Permit Number 306097006

AT 539 AUBURN ST #1 382A D021001

Proposed Project Description:
FOUNDATION ONLY CONNECTED W/ PERMIT#060702

Dept: Building **Status:** Approved with Conditions **Reviewer:** Tammy Munson **Approval Date:** 06/30/2006
Note: **Ok to Issue:**

ALTERNATE BASEMENT FOUNDATION PLAN

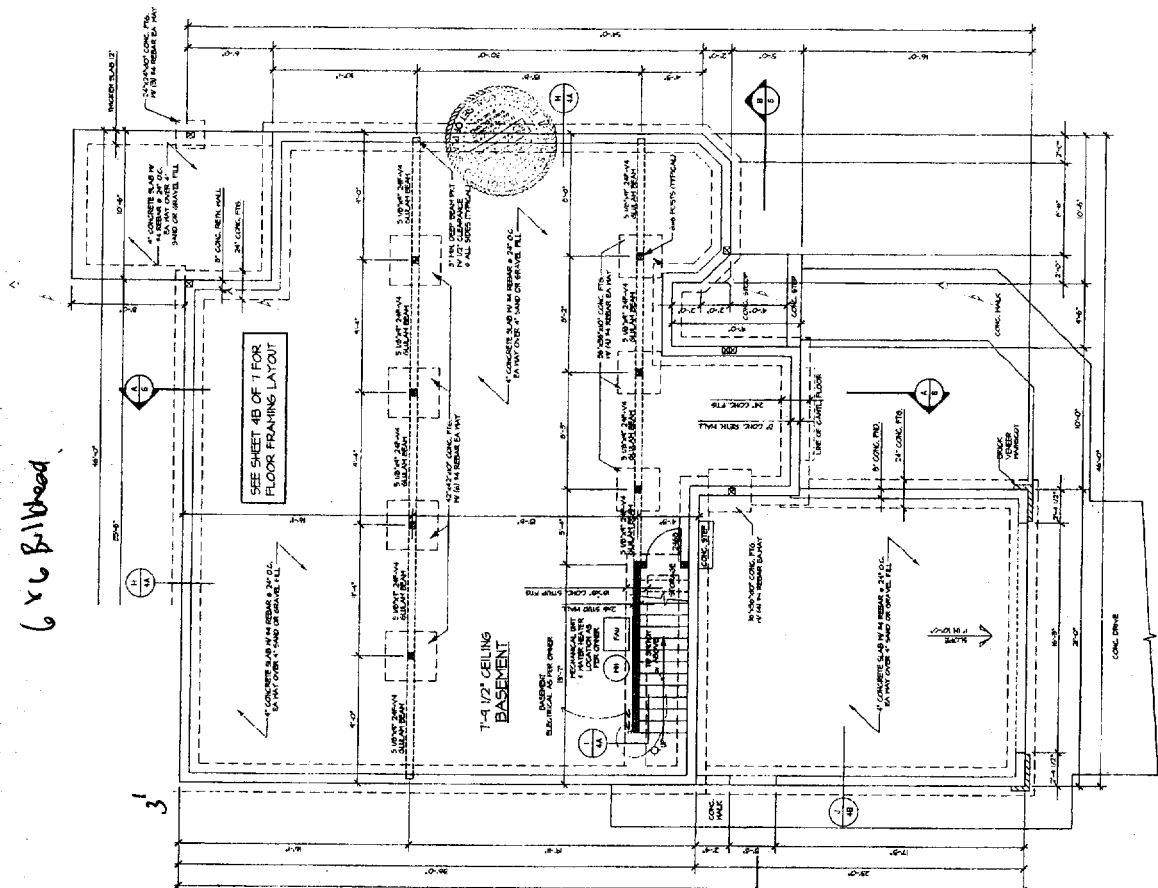
- 1) A 48" deep frost wall must be insatlled under the garage as discussed w/contractor/owner.
- 2) Filter fabric must be installed over the drain tile.
